From: Sarah Fawdry [REDACTED]
Sent: 02 March 2023 15:55
To: Jessica Riches; David Easton
Cc: Chris Brake; Katie Martin; Martin Kempshall; Thomas Richards; Silvie Steiningerova
Subject: Bilsham Road, Yapton - Y/70/22/DOC and Y/34/22/DOC
Attachments: 2023 02 08 Y 70 22 DOC Drainage Response.pdf; D1956-13-200B Proposed Levels Layout.pdf; D1956-13-201B Proposed Levels Layout.pdf; D1956-13-202B Proposed Levels Layout.pdf; D1956-13-300B Proposed Permeable Paving Formation Levels.pdf; D1956-13-301B Proposed Permeable Paving Formation Levels.pdf; D1956-13-302B Proposed Permeable Paving Formation Levels.pdf

Having recently picked up comments on your online portal regarding Y/70/22/DOC (dated 8 February 2023; attached for ease), please find our responses to the outstanding queries as follows. For ease and completeness, I have followed on from the previous queries with our responses, our latest response is detailed in green.

Drawing No. **D1956-15-100** Rev. **A**

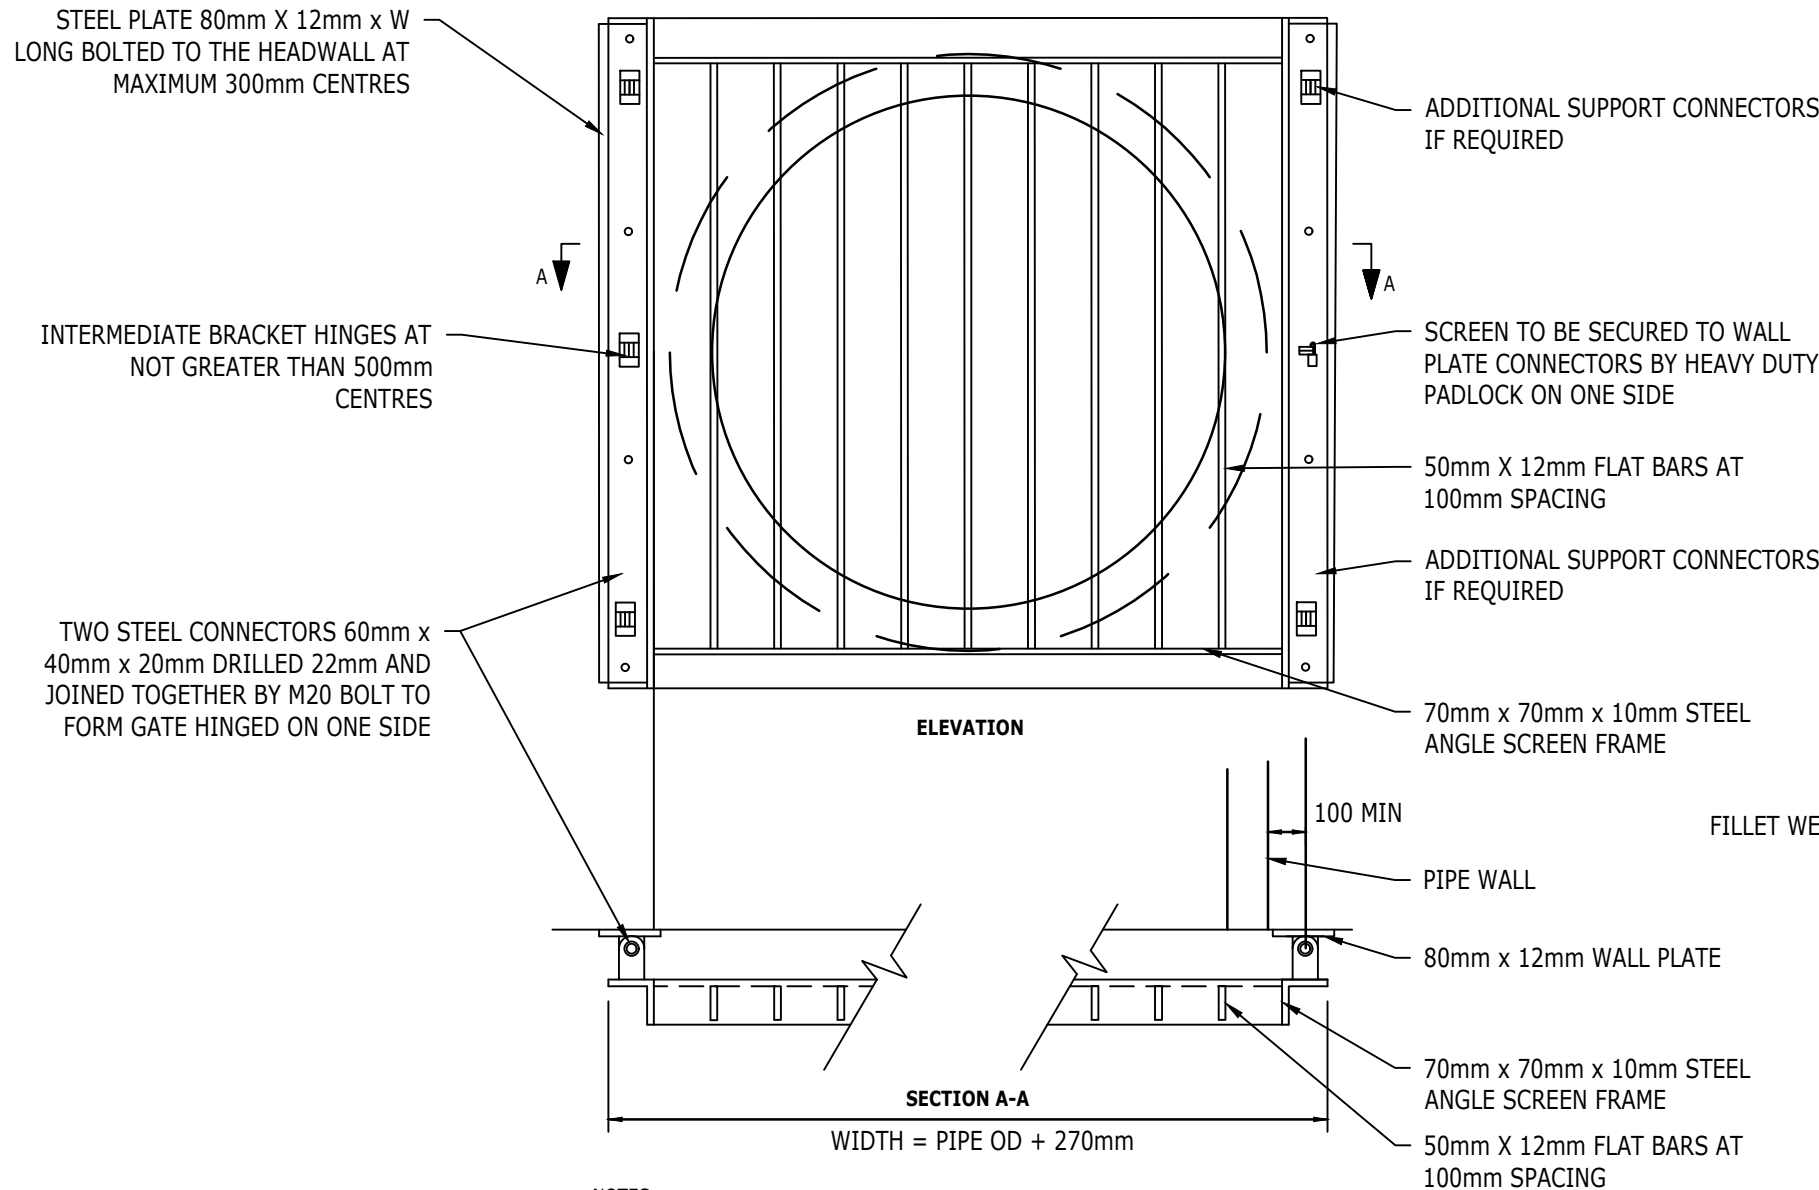
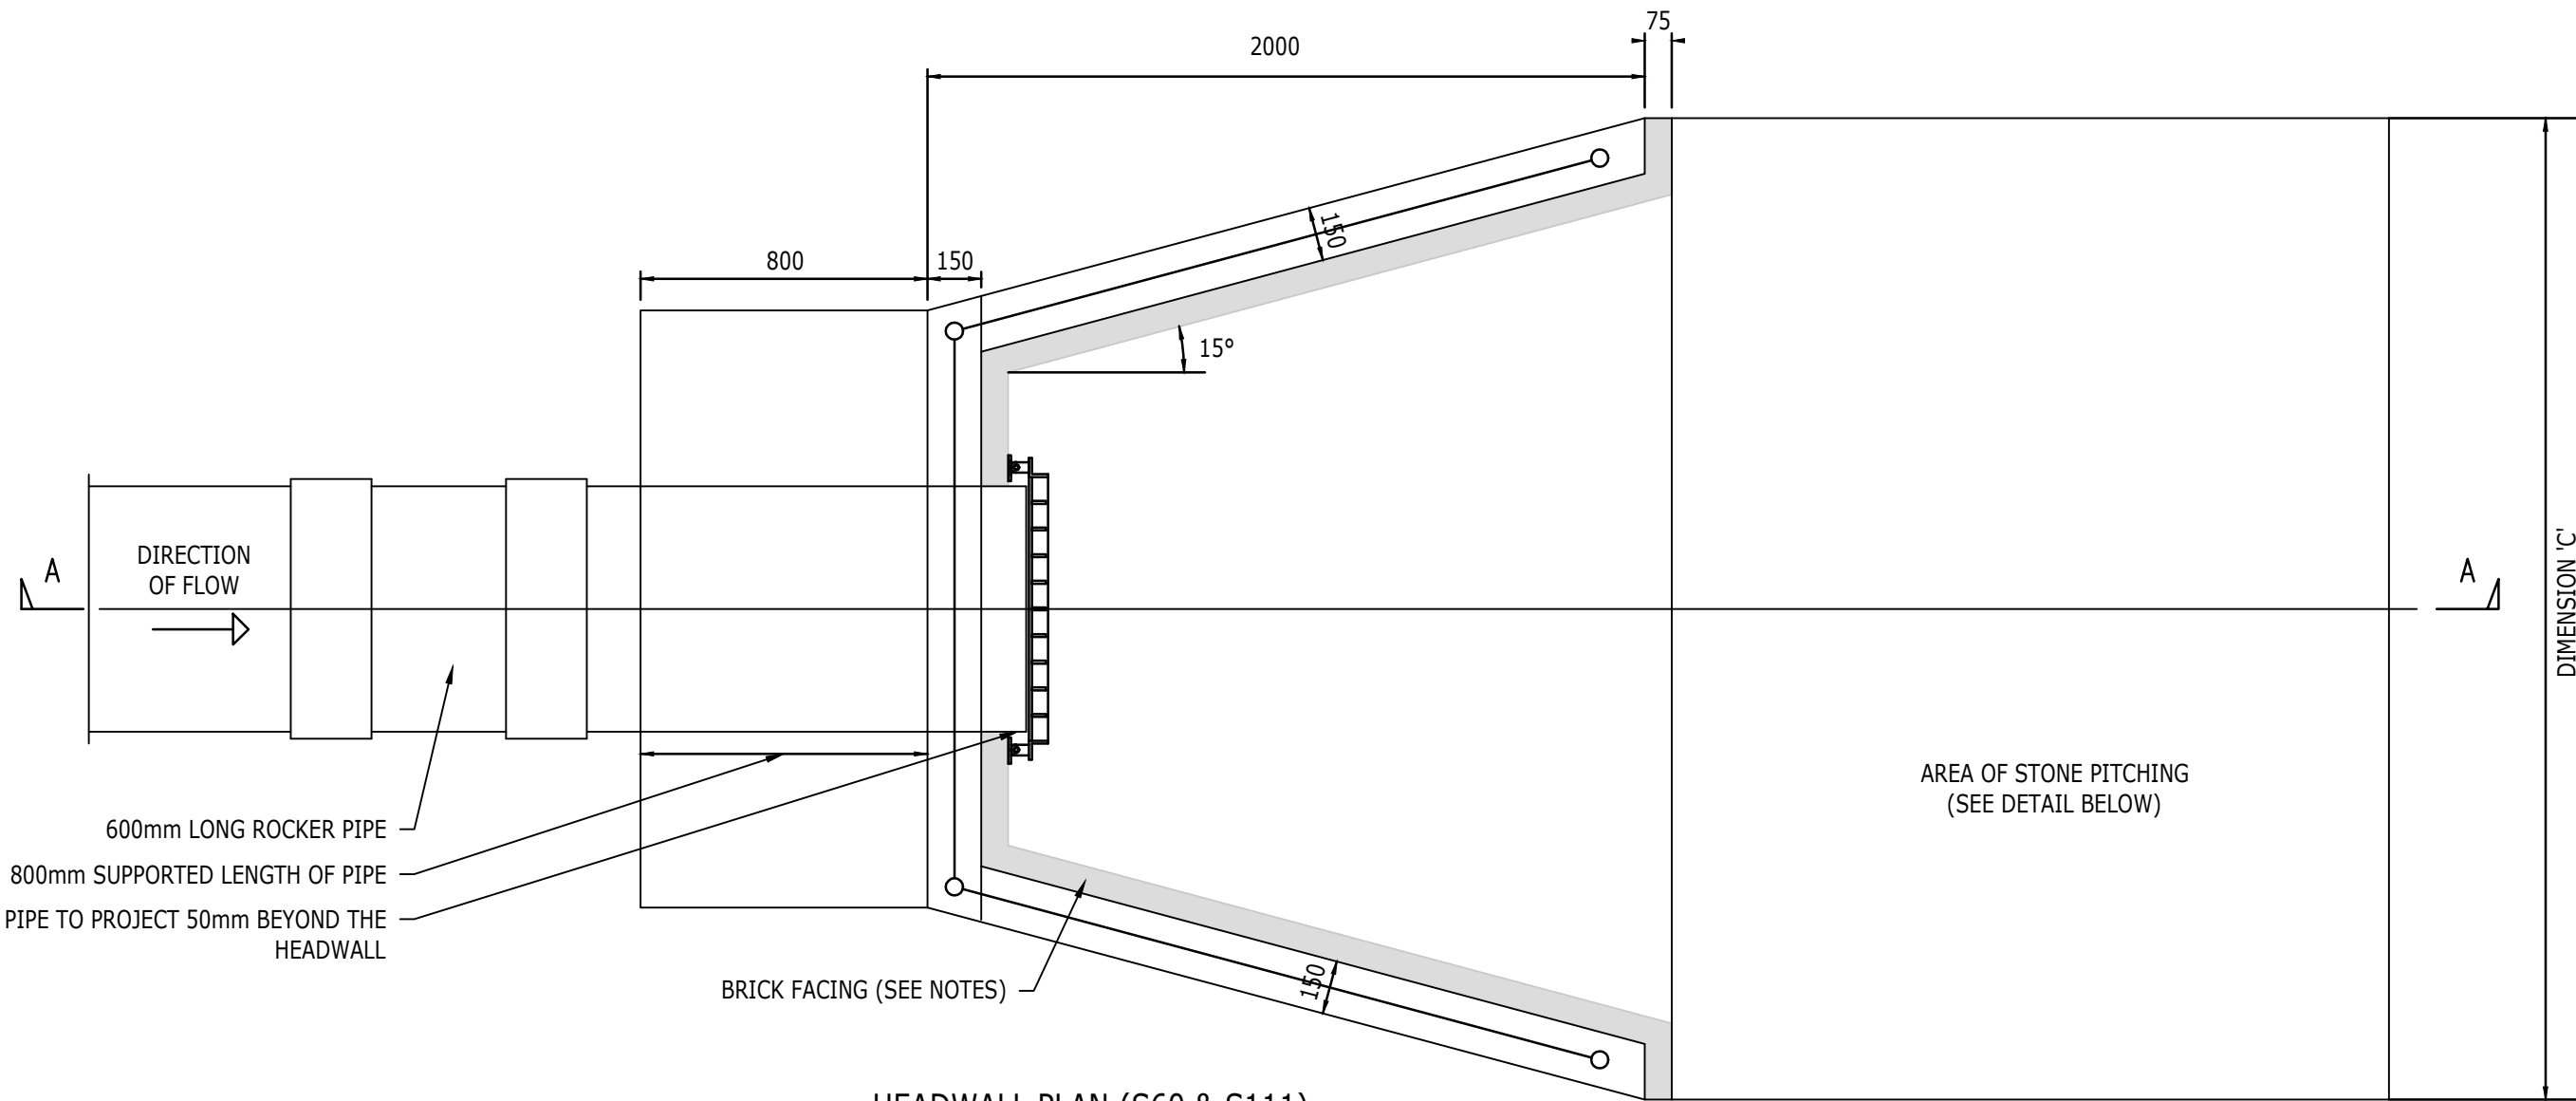
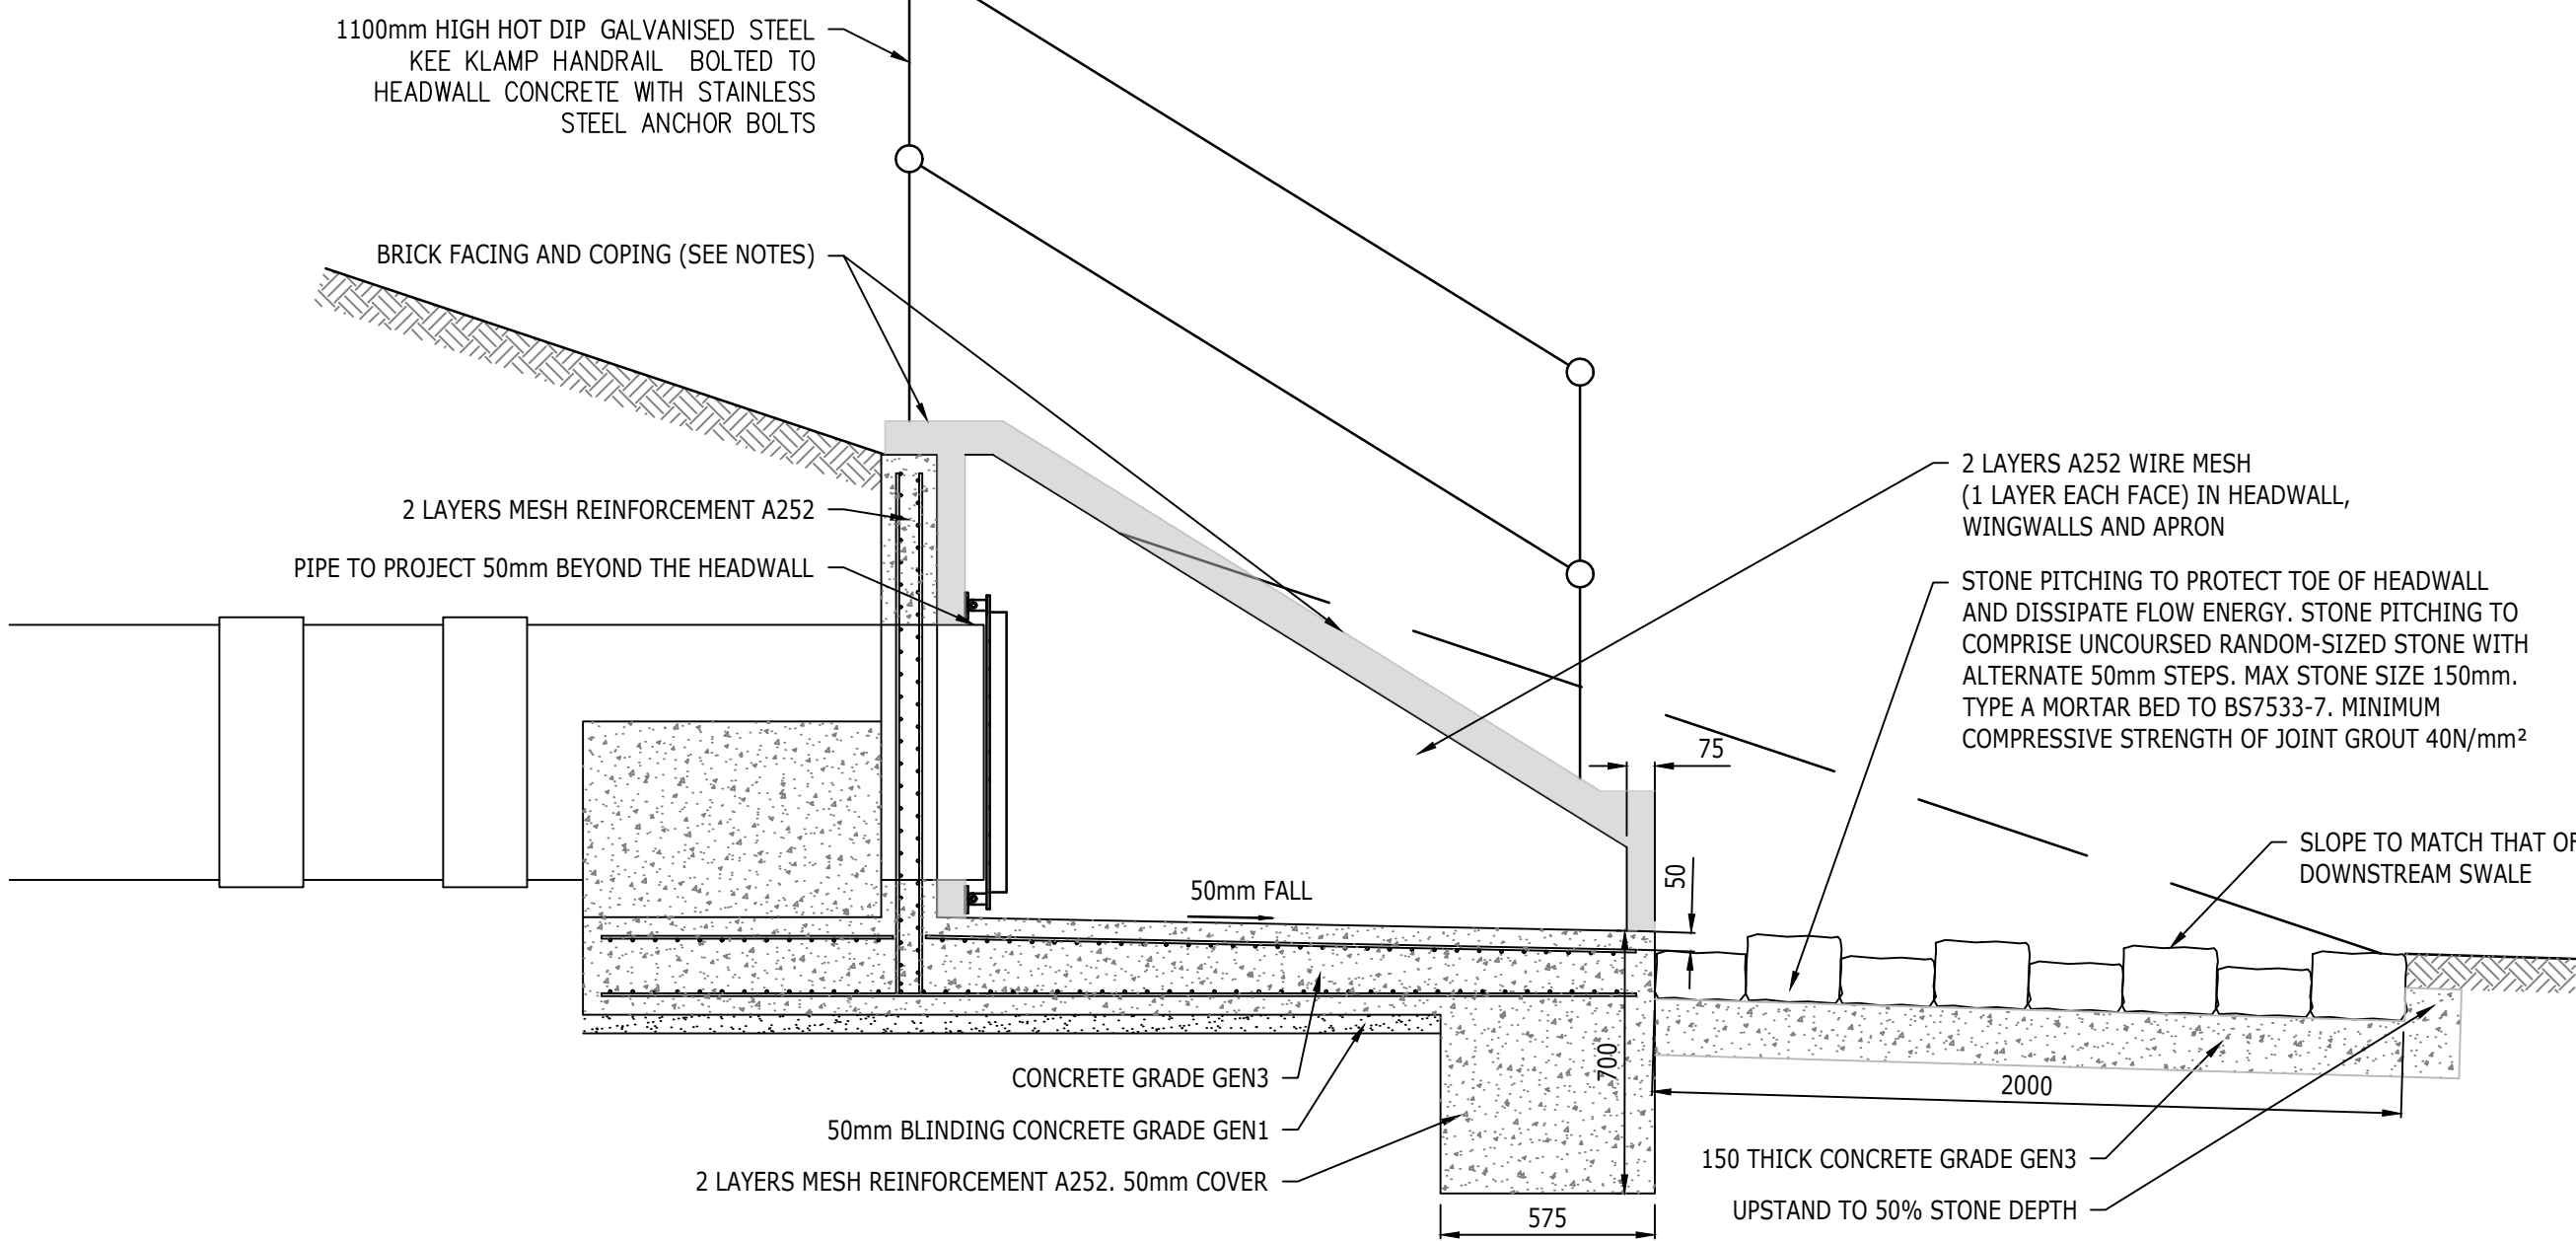
11. Please provide cranked grilles at a 45 degree angle. - Cranked grilles required on heads – S104 Construction details sheet 1 of 2 D1956-15-100 needs to be updated to suit ADC requirement. Pipe beddings details on this drawing are illegible in parts. Information needs to be clearly presented. We note that applicant's response that this is not "DSG compliant" however the drawings refer to Sewers for Adoption 7th Edition. As such the applicant needs to be clear which edition of Sewer for Adoption the adoptable drainage is being designed to. In addition they should confirm who the adopting authority will be as well as confirmation from the adopting authority on whether they will or will not accept cranked grilles. 08/02/2023- Whilst it is noted that the Technical Approval certificate has been provided for information, this doesn't clarify whether the adopting authority has considered a request to use cranked grilles. This needs to be confirmed by the adopting authority otherwise cranked grilles should be used TH: There is no provision in DCG for the use of cranked grilles, only grilles installed flat against the headwall. In addition, we consider that cranked grilles create a health and safety issue as they could encourage people to climb up on them up to a perch from which people could fall.
